Our ref: XA/2025/100338/05-L01
Your ref: EN010157
Date: 31 October 2025

ENVIRONMENT AGENCY RESPONSE TO DOCUMENTS SUBMITTED AT DEADLINE 3.

PEARTREE HILL SOLAR FARM, EAST YORKSHIRE.

#### Figure 3.6: Indicative Culvert Crossing Points

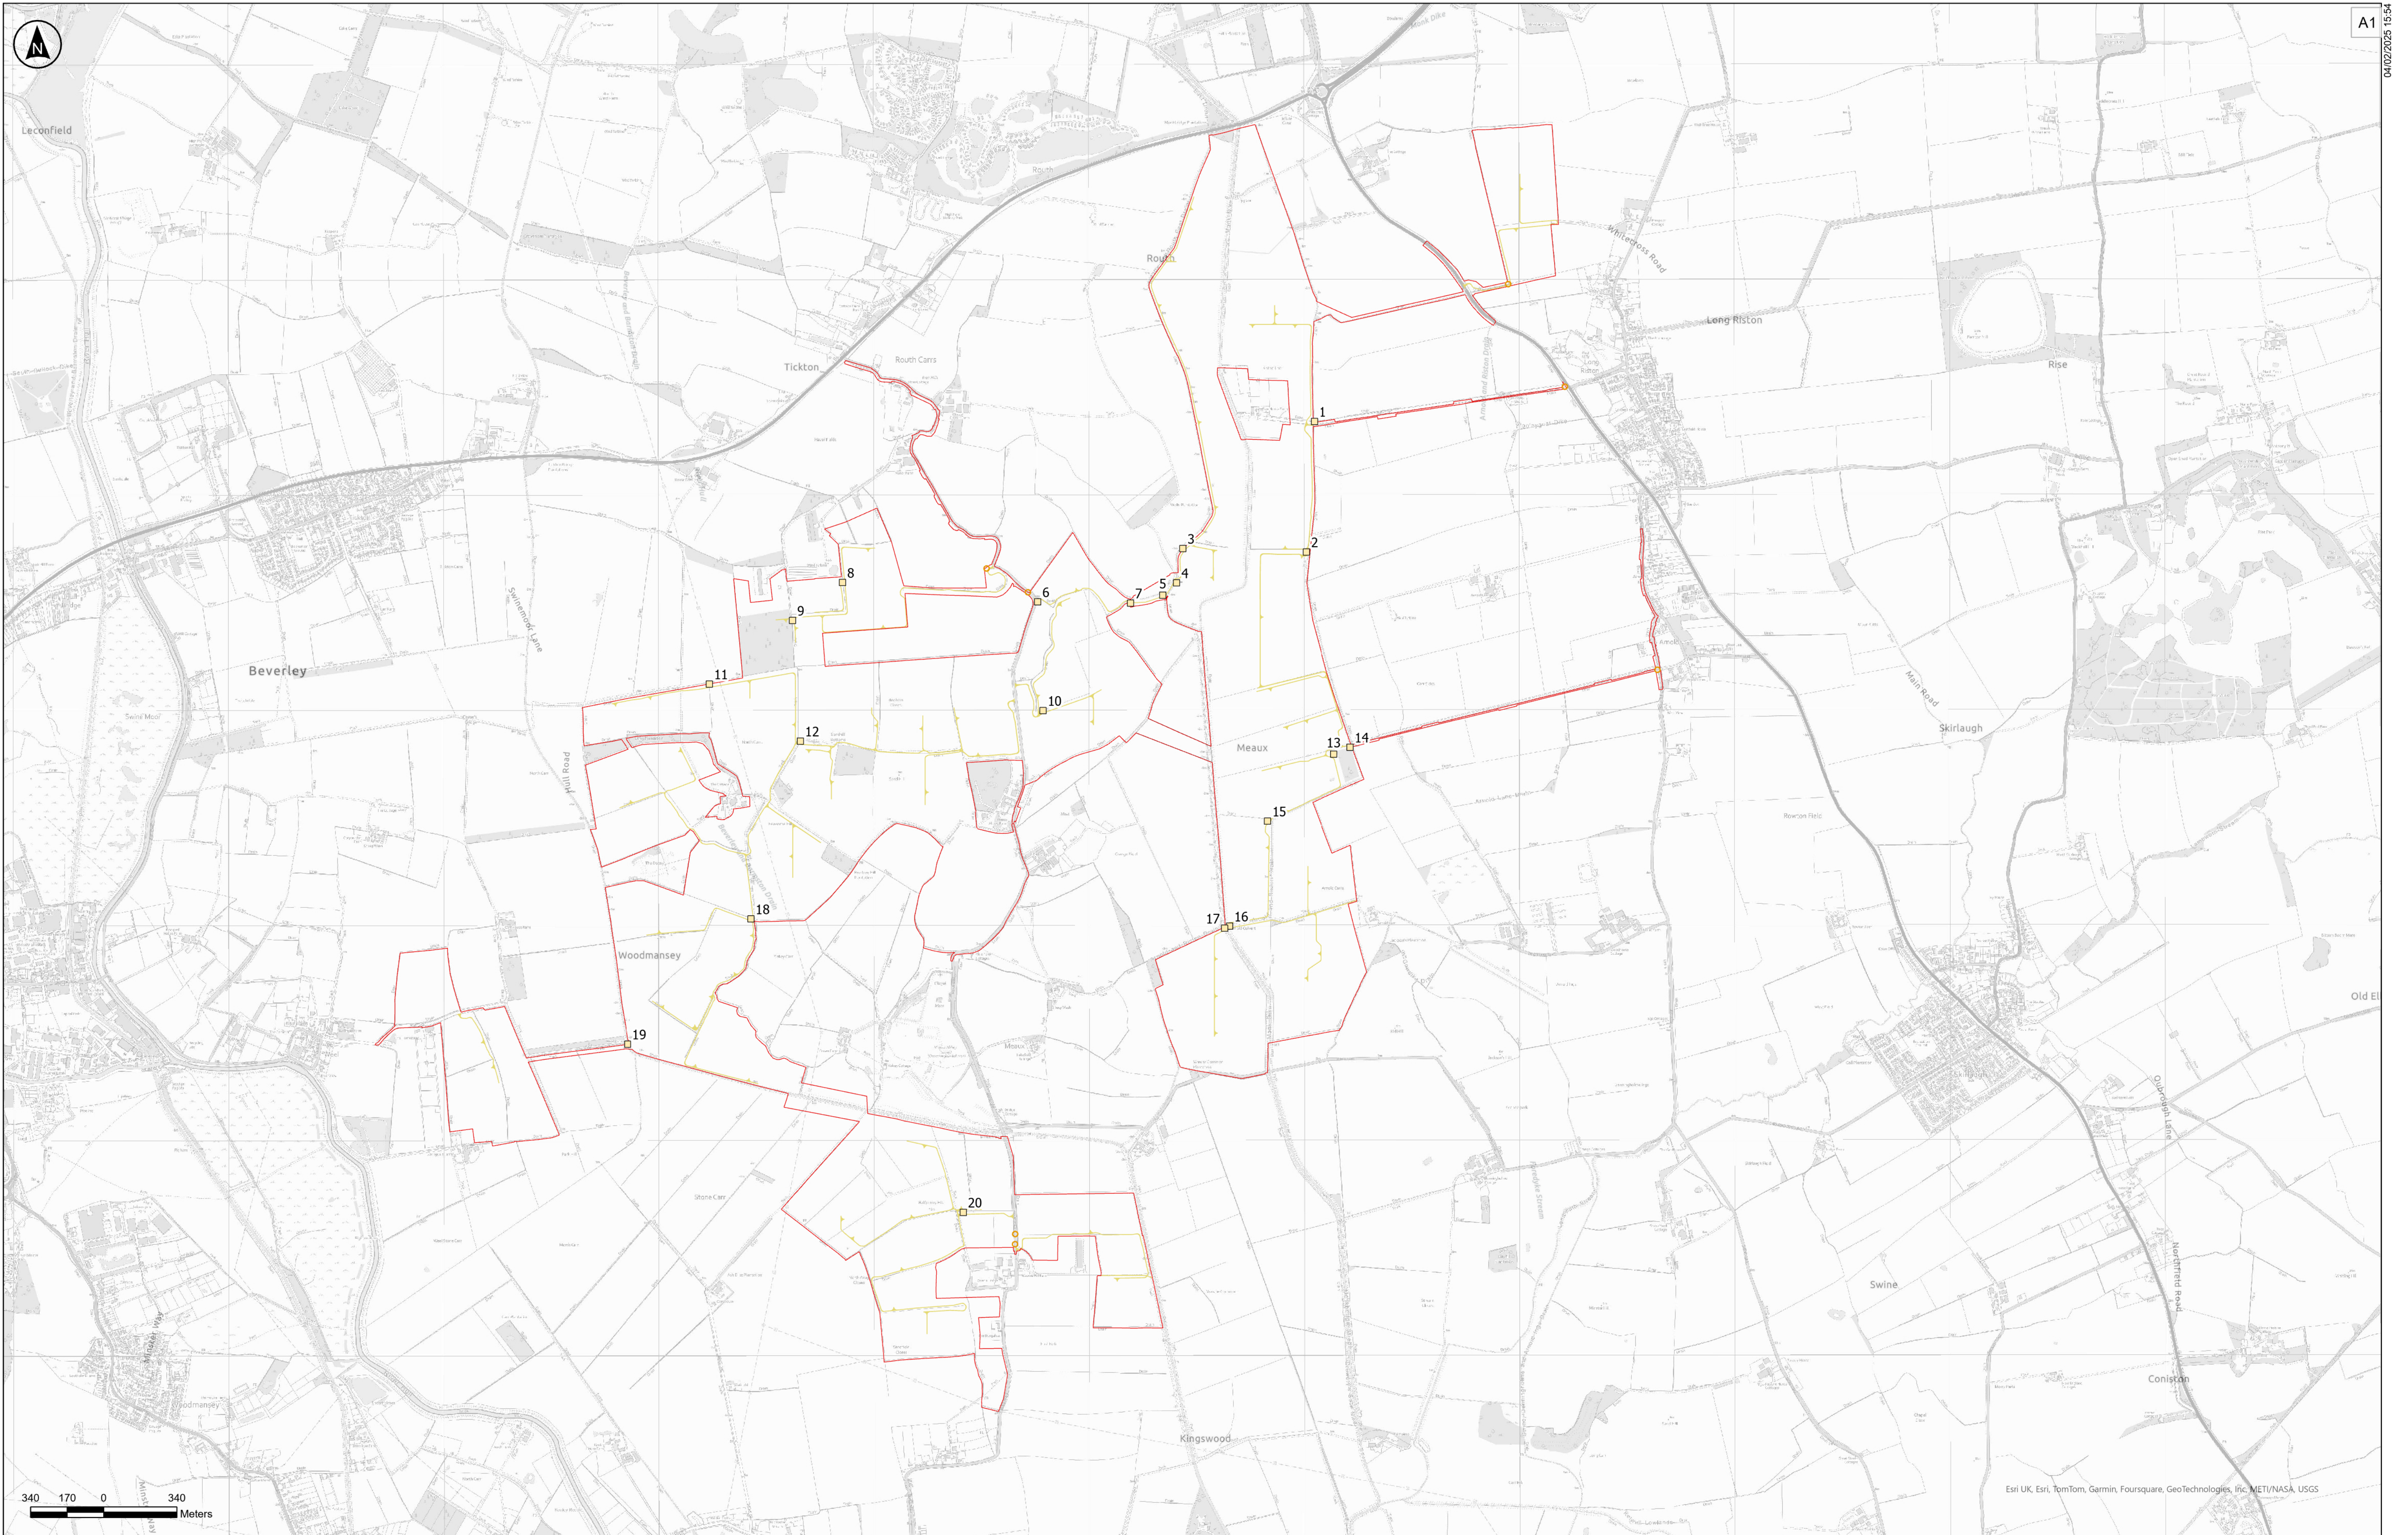
The Applicant and EA held a meeting on 30 October to discuss this matter. Within the meeting the Applicant clarified that the crossings presented in Figure 3.6 'Indicative Culvert Crossing Points' are not all above ground new culverts and that in some locations there are existing crossing that may be able to be used. The EA has requested the Applicant makes clearer within the figure, by colour coding, where the proposed crossings and existing crossings are located.

Additionally, the Applicant signposted the EA to the hydraulic modelling that the Applicant has undertaken and confirmed that they have updated the model to include missing existing crossings. However, the Applicant has not undertaken a model run that includes the maximum possible number of new culvert crossings in order to assess the possible worst-case scenario, which was requested by the EA. The Applicant has committed to reviewing how many crossings may need to be assessed. This was suggested to be only around two new culverts which would have minimal impact.

This issue remains outstanding. However, discussions are ongoing, and we expect to be able to resolve this prior to the close of examination.
